**From:** Sarah Fletcher <fletchsa1@gmail.com>  
**Sent:** Sunday, March 26, 2023 4:51 PM  
**To:** Roxanne Navrides  
**Cc:** Ryan Harriman; Suzanne Skone; Dan Thompson; Mike or Susie Cero; Carv Zwingle; Thomas Acker; Council; Traci Granbois; Robert Medved; Jessi Bon; Alison Van Gorp; Bio Park  
**Subject:** Re: Public Comments SUB 19-002/Boys and Girls Club Long Subdivision

Dear Ryan, I am a long-time resident of Mercer Island, and have been involved in this subdivision since the property was originally purchased from the Boys and Girls Club, a very unfortunate situation. The purchasers never honored their promise to build and provide ballfields for Island youth and the city never required a deed on the property despite the fact the Boys and Girls Club, city, and private citizens spent several million dollars to build Peak rather than buy this parcel for roughly the same price. Many citizens, and council members, felt deceived.

PRELIMINARY ROAD PLAN & SECTIONS
2825 W MERCER WAY
PRELIMINARY PLAN
PARCEL #2174502425
CITY OF MERCER ISLAND WASHINGTON

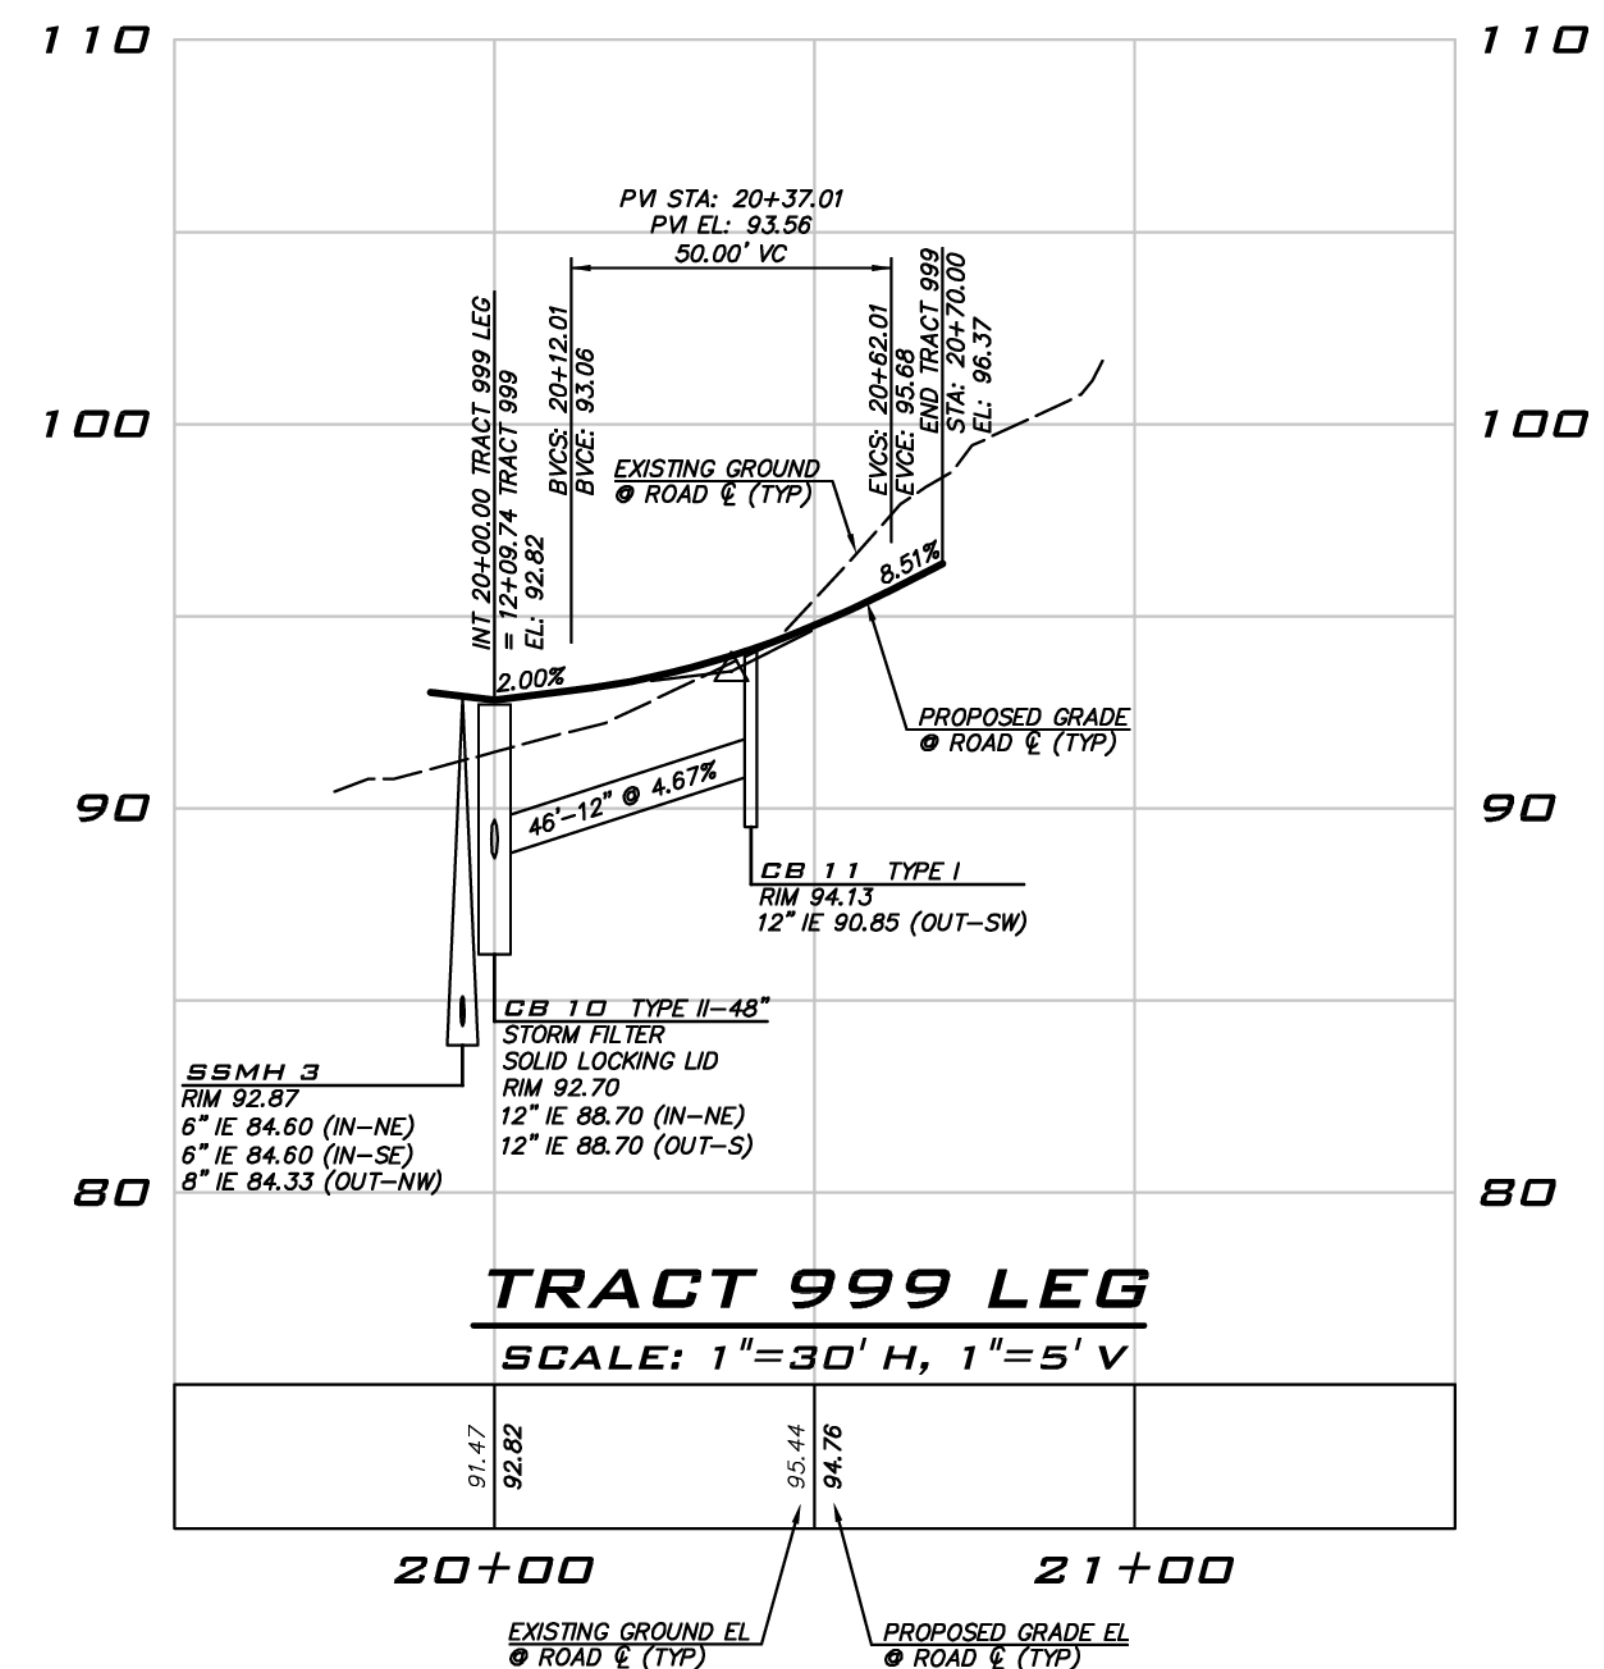
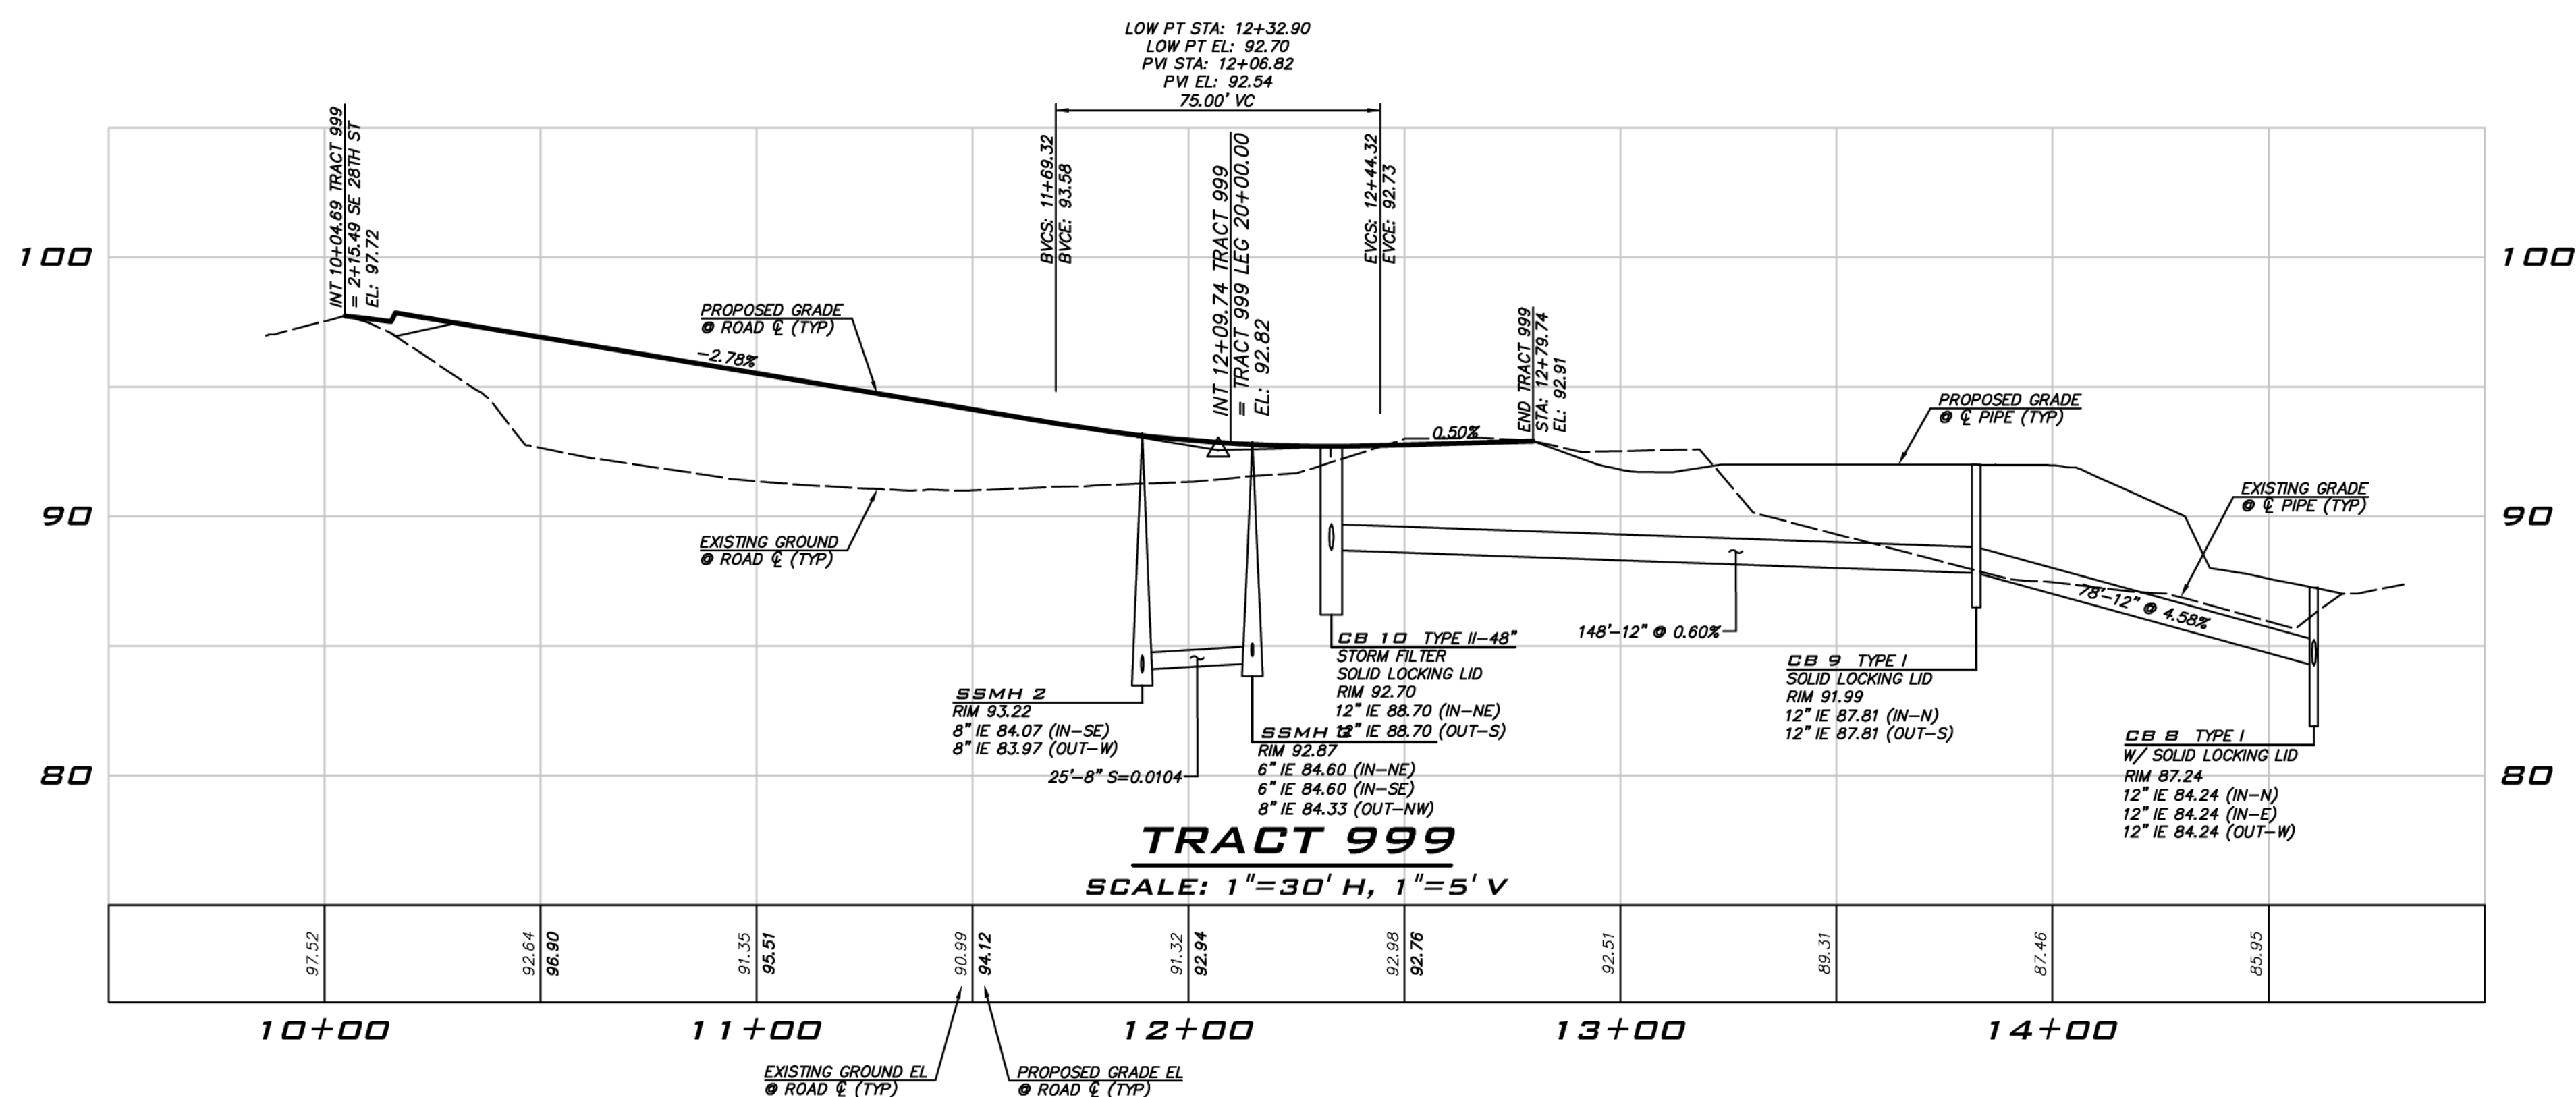
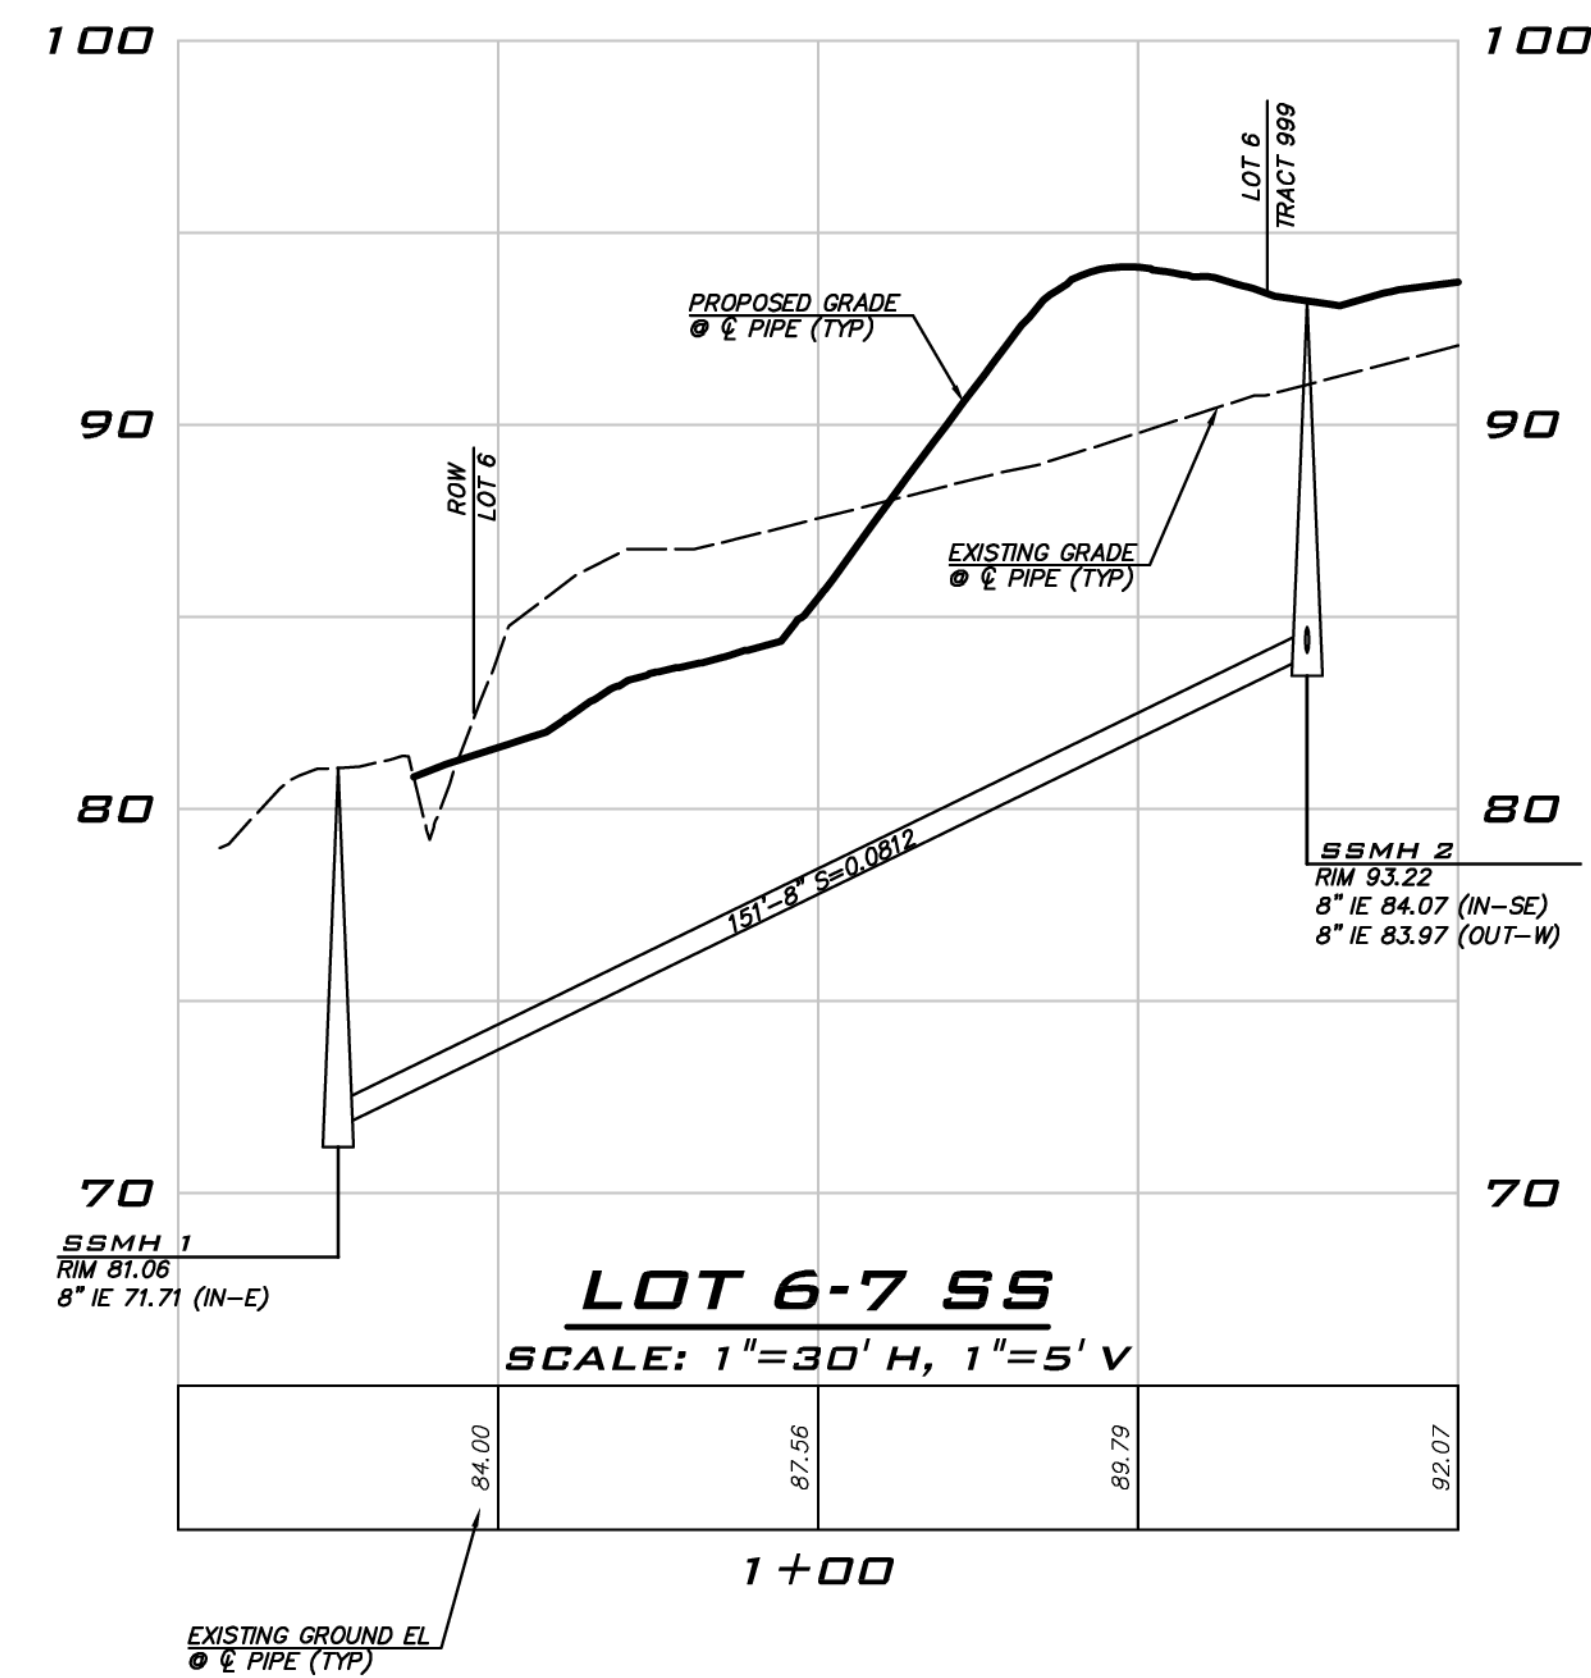
B. Ingress and egress should be by internal road for each house. The applicant no doubt does not like this since the internal road counts against lot area and lot coverage limits, but in my opinion the current plans are a danger to those walking or biking along adjacent streets. There is some internal access to some lots, but all access should be by an internal access road.
